October 9, 1979

Re: Lot 22, Kachina Hills 2

DRAINAGE REPORT
FOR
KACHINA HILLS UNIT 2
ZONE ATLAS SHEET H-23

DRAINAGE REPORT
FOR
KACHINA HILLS, UNITS 2 AND 3
ZONE ATLAS SHEET H-23
AUGUST, 1977

PRELIMINARY PLAT
UNIT 3, KACHINA HILLS
ALBUQUERQUE, NEW MEXICO
SCALE: 1"=100' JULY 1977

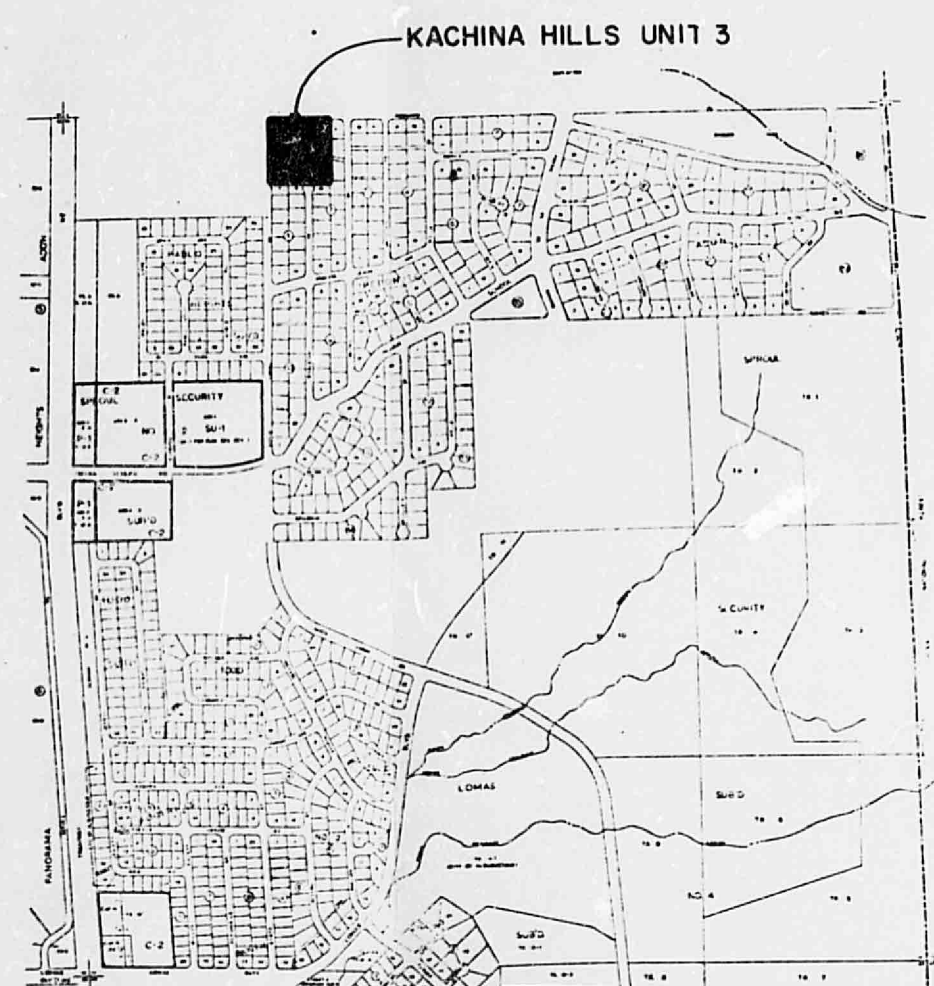
1. The lots adjacent to the arroyo will not drain into the proposed swale but will have backyard ponding.
2. No swale is to be constructed on the berm adjacent to the channel.
3. Valdez Drive will be graded to drain into Rebonito Rd. and will intercept the flows from offsite areas G & K.
4. The developer will supply the City with a letter of agreement accepting the responsibility of the silt removal from Monte Largo until further development to the east will have eliminated this nuisance.

This is to inform you that items 1 through 3 of your conditional approval letter dated September 29, 1977, for the above-referenced drainage report are presently being incorporated into the construction drawings.

PRELIMINARY PLAT
UNIT 2
KACHINA HILLS
ALBUQUERQUE, BERNALILLO COUNTY, NEW MEXICO
SCALE 1" = 100' JANUARY 1977

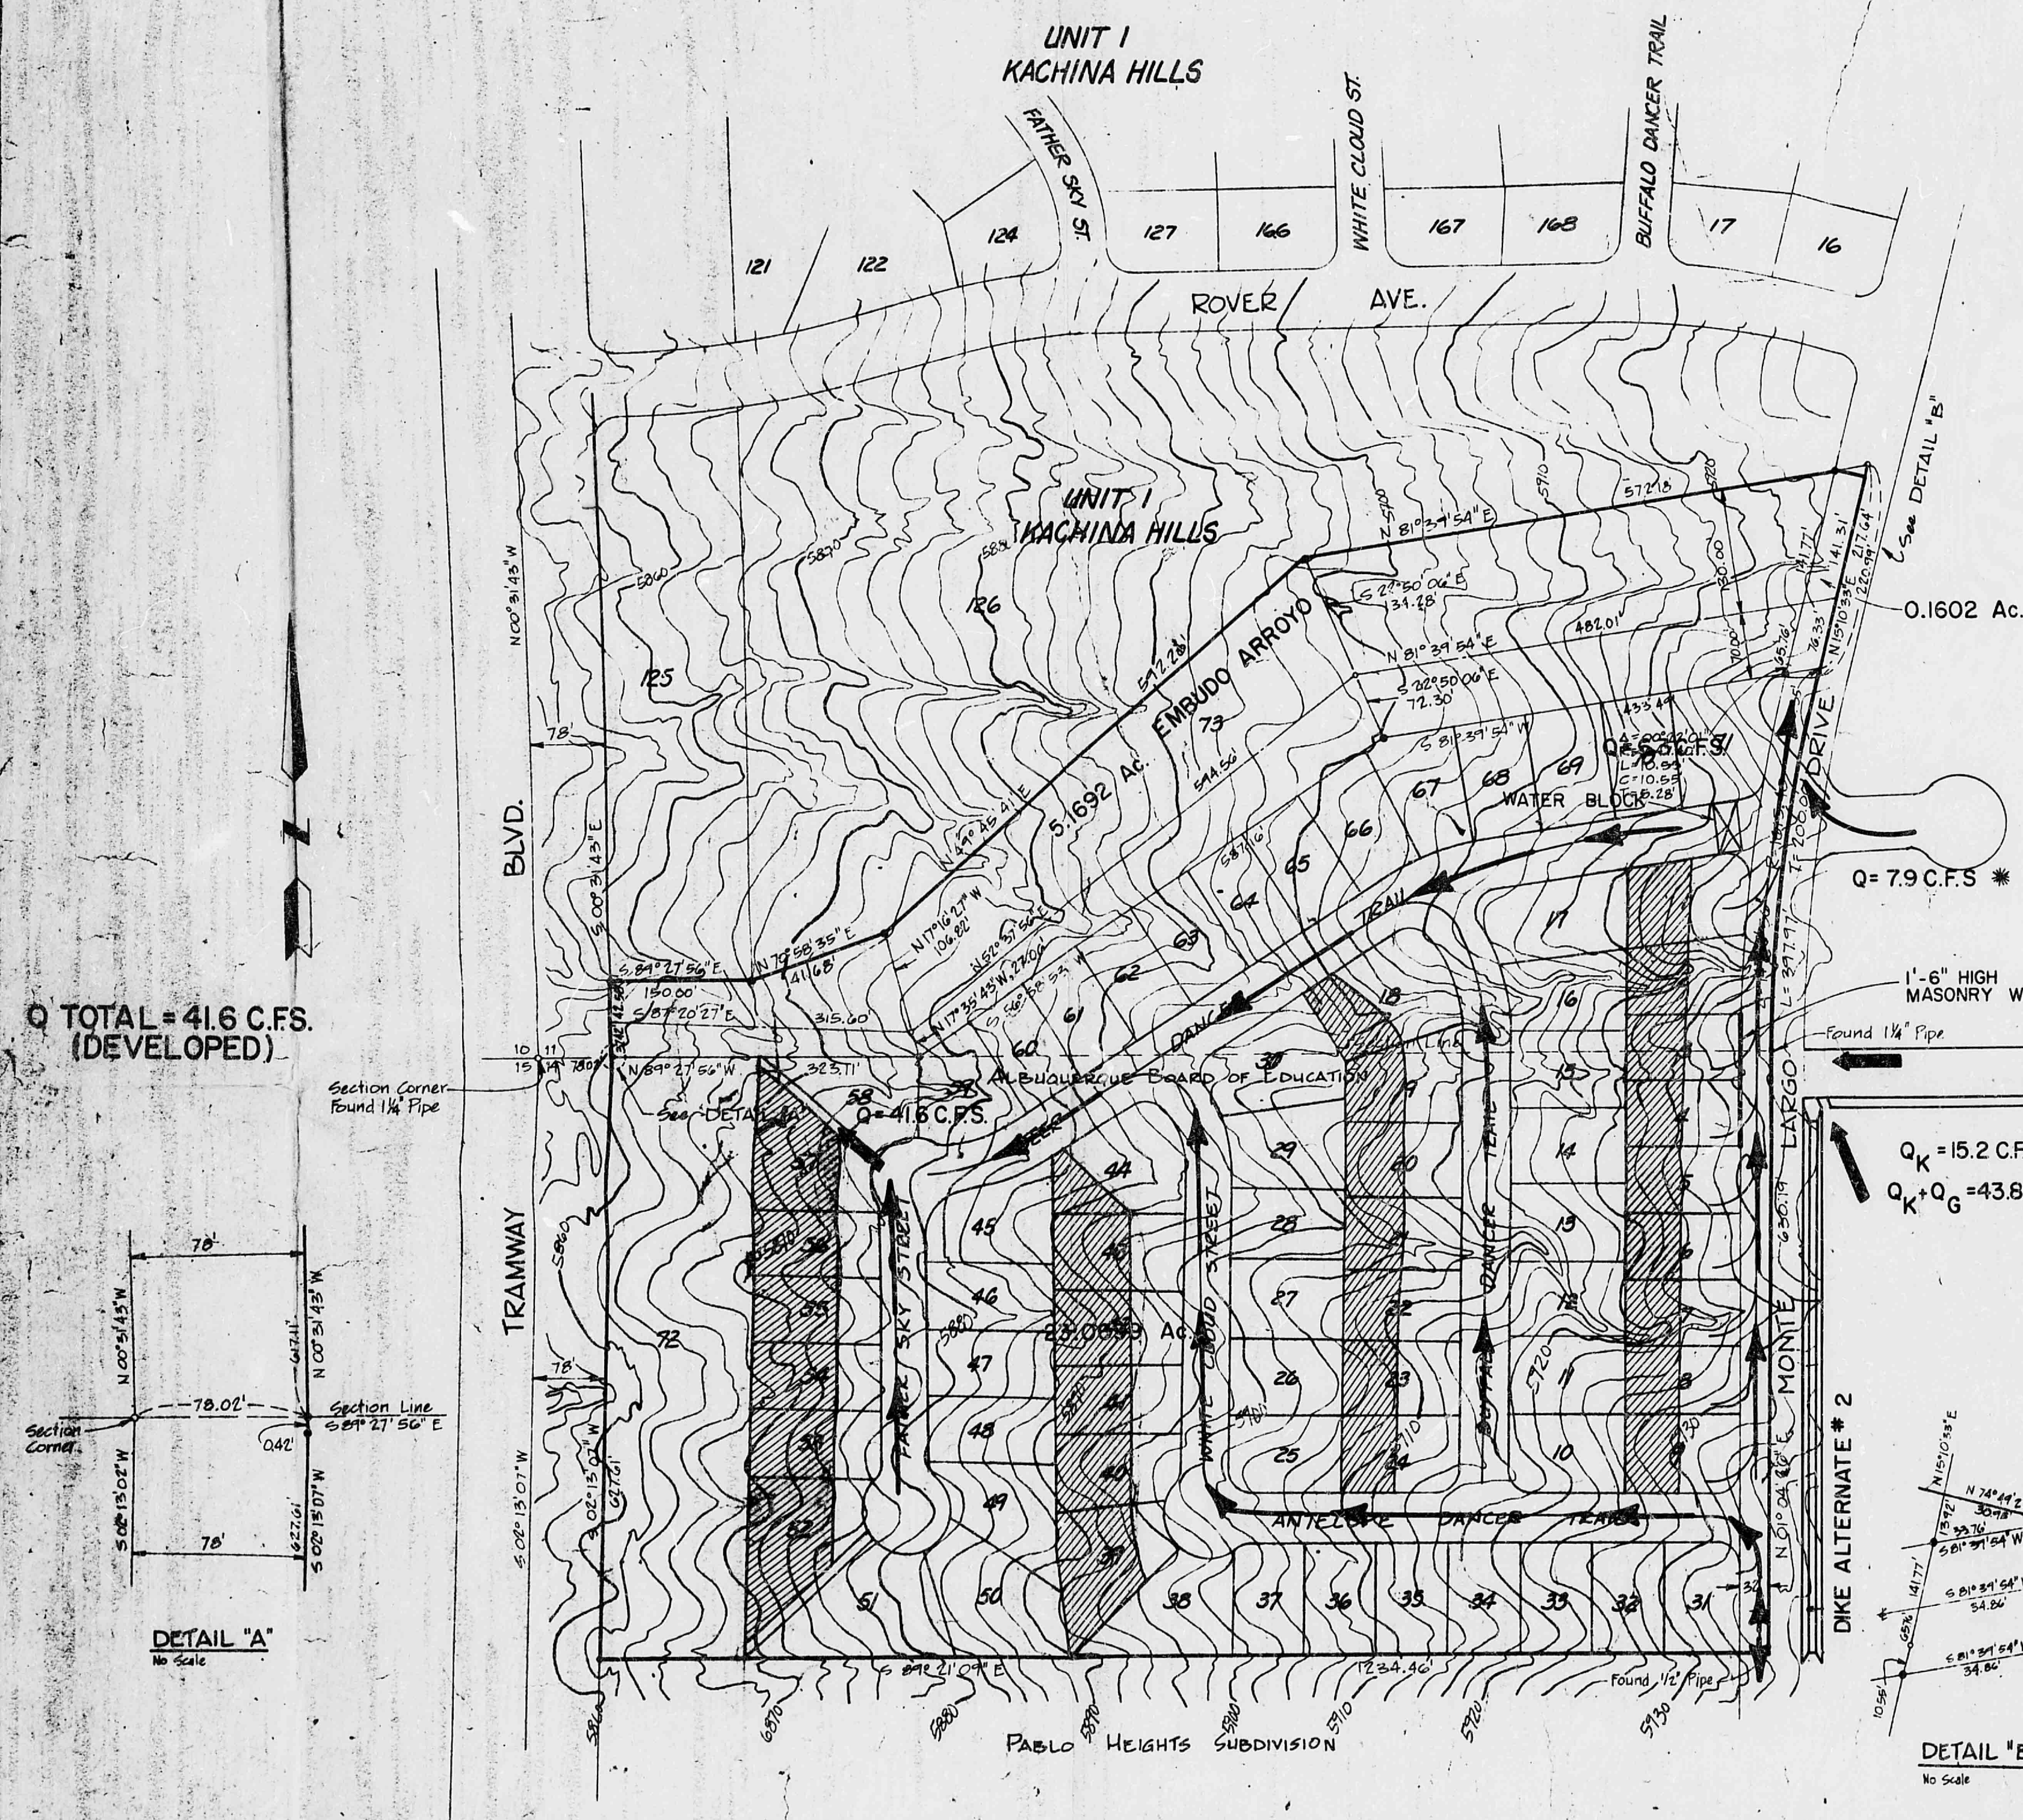
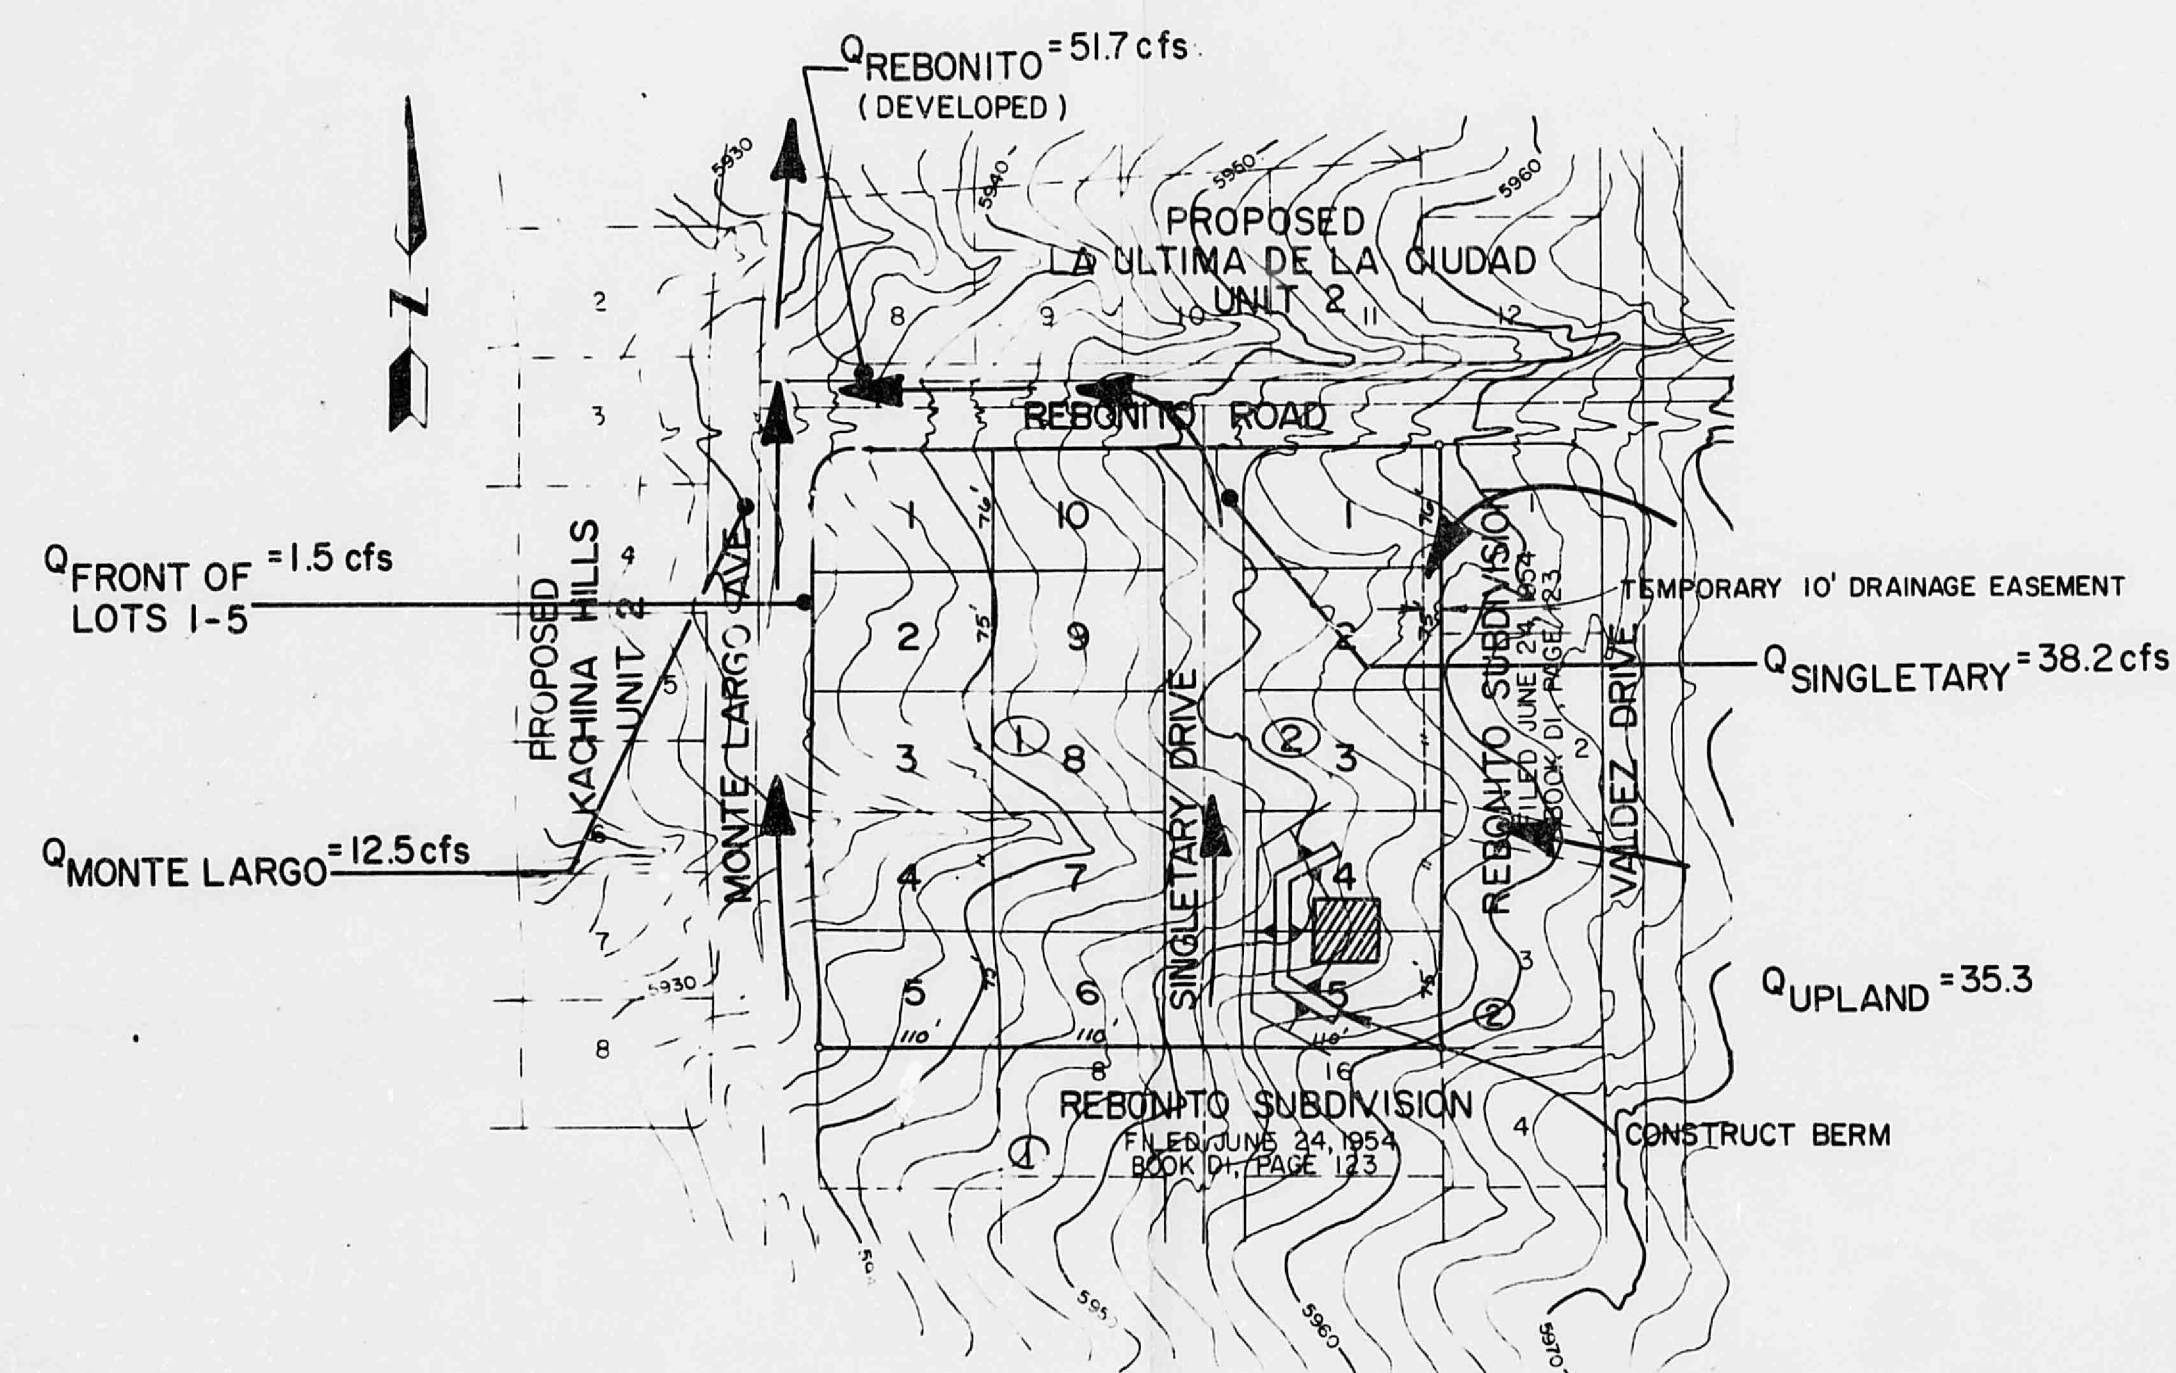
The construction of a dike to intercept the upstream flow and allow a downstream development is not acceptable in principle. The owners of the upstream property are entitled to continue to drain their property at the natural point of discharge. Any modification of the natural drainage pattern performed for the benefit of a downstream development must not cause any hardship nor inconvenience to others be they private or public.

On the basis of the consideration above, which are clearly specified in the AMAFCA Resolution, the proposed construction of interceptor dikes concurrently with the development of "Kachina Hills Unit 2" are not acceptable. Dike alternate #1 would be constructed in public road r.o.w.--such construction would:

1. Deny access to the owners of property adjacent to the road r.o.w.
2. Subject properties adjacent to the dike to inundation and to sediment deposition.

Dike alternate #2. Same objections as alternate #1; in addition, this alternate would transfer the responsibility of the runoff management to the public by conveying the runoff to Monte Largo Drive.

The drainage report of February 1977 has been reviewed. Flows directed into the Embudo Arroyo should be slowed to 8fps or less unless arroyo is lined. The portion of the Embudo Arroyo passing through the development remains the responsibility of the developer. Information must be included in the report regarding permanent improvement of this temporary channel.

It is our understanding that AMDEC has supplied you with a letter of agreement accepting the responsibility for silt removal on Monte Largo Drive as you requested.

Finish floor elevations of residences fronting onto Monte Largo Drive near Rebonito Road will be elevated as far as possible while conforming with the restraints imposed by the driveway grades.
